**Lindfield Learning Village**

Traffic and Transport Assessment -  
SEARs Comment Response

Issue | 20 November 2017

Landscape Blow Up Plan 8
Bus turnaround extended driveway zone

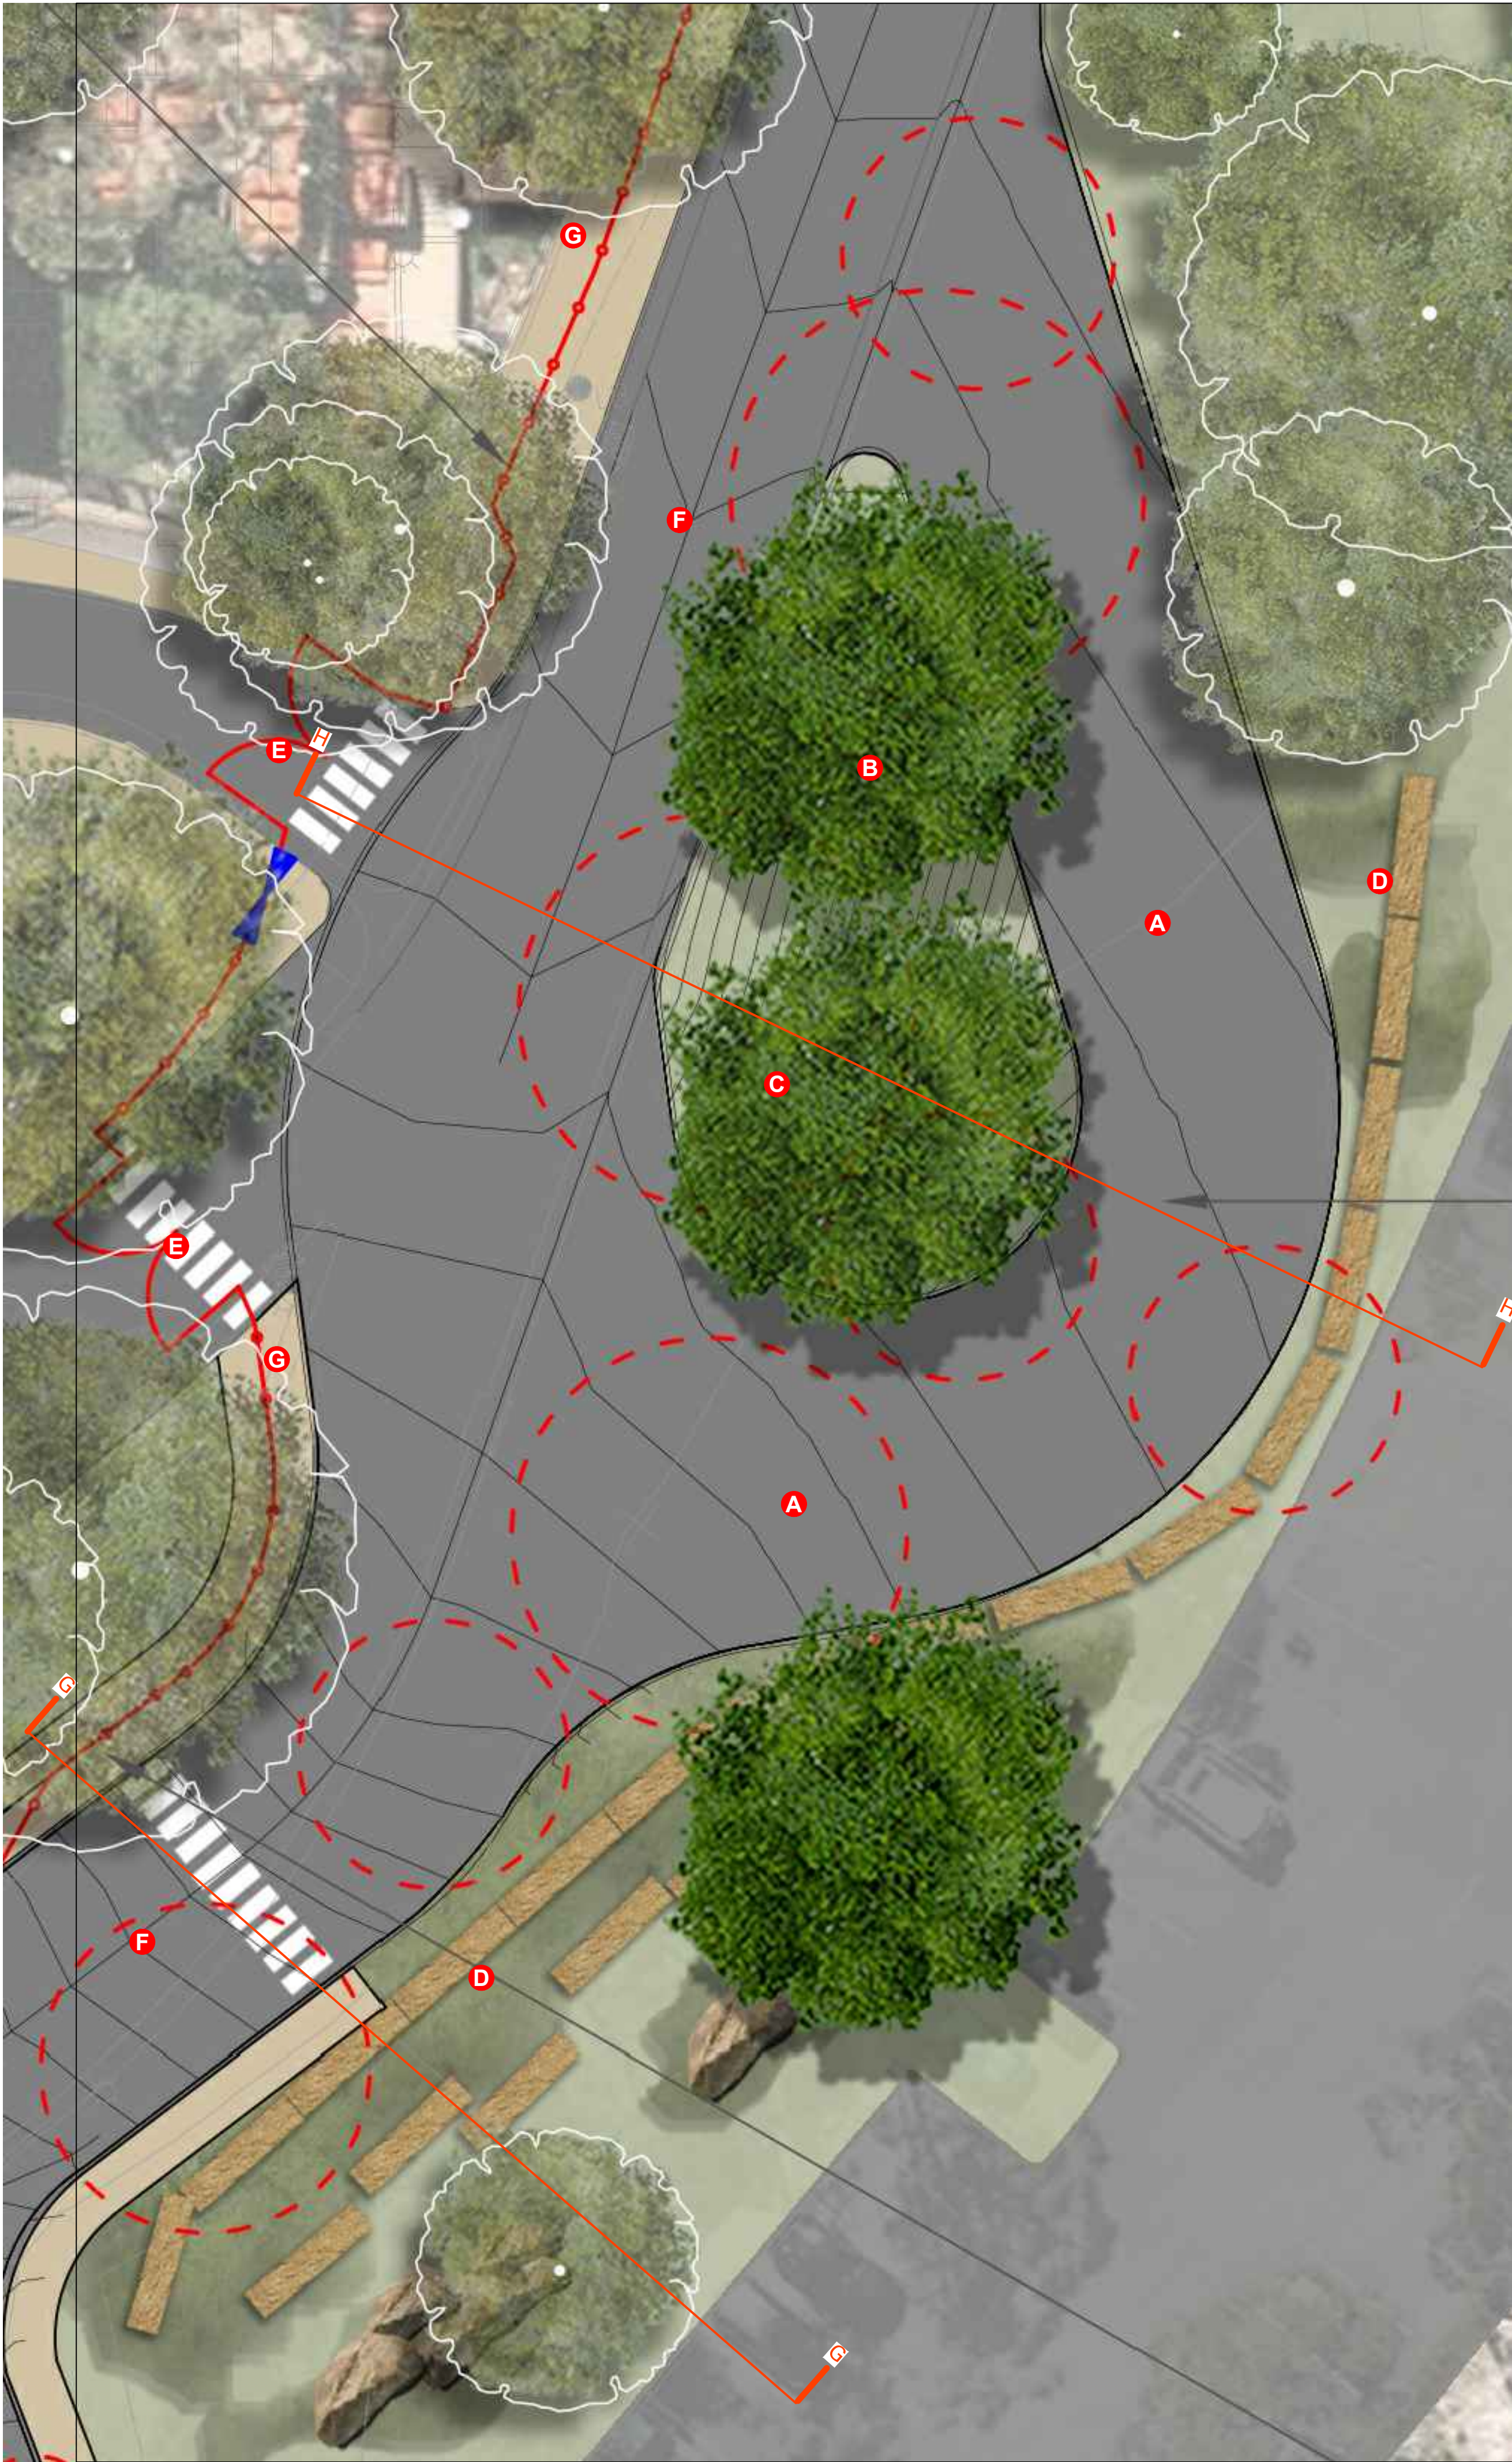
R4	[2.2] Buses using the bus bay do not appear to have enough clearance to safely navigate the bus bay without rubbing up against concrete walls or pedestrian fences. The 600mm body clearance has not been achieved.	Please refer to revised swept paths in Appendix A.

R#	Comment	Arup response
R5	[2.3] Buses exiting the bus bay are required to mount the western kerb of Eton Road when turning right. This will damage the kerb as it is repeatedly run over by buses as well as increase the wear and tear of buses.	Please refer to revised swept paths in Appendix A.
R6	[2.4] The existing bus bay cantilever structure was constructed to a single bus at the time. Roads and Maritime requires clarification that the existing structure can handle the extra 3 buses, passengers and kerb without failing.	A structural review is underway.
R7	[3] Roads and Maritime will not support non-standard School Zone times.	<p>Based on consultation, RMS is unresponsive of school zones given it is a policy change issue which will take time to implement. It was agreed in the meeting that temporary measures will be investigated and implemented, such as appropriate signage and to calm traffic in the area. This is until a change in school zone policy is made in the future.</p> <p>DPE has highlighted the need for this policy revision given staggered start times will be more prevalent with schools in the future. It was agreed that staggered start and finish times help ease traffic conditions and will only be required for Stage 2 of the project. RMS is willing to review this policy at a later stage when more schools require this policy change.</p>

To improve student queuing at the bus bay and to retain the existing roadway for bus turning, an alternative design with a pedestrian walkway extended to the inside of the existing structure is being investigated, illustrated in Figure 1. The proposed design would have a three-metre-wide footpath.

The existing central void is also proposed to be cut back by extending the bus access road into the void. This is to allow the 14.5 metre buses to negotiate the bend with sufficient clearances, with an indicative plan and swept paths shown in Figure 3.
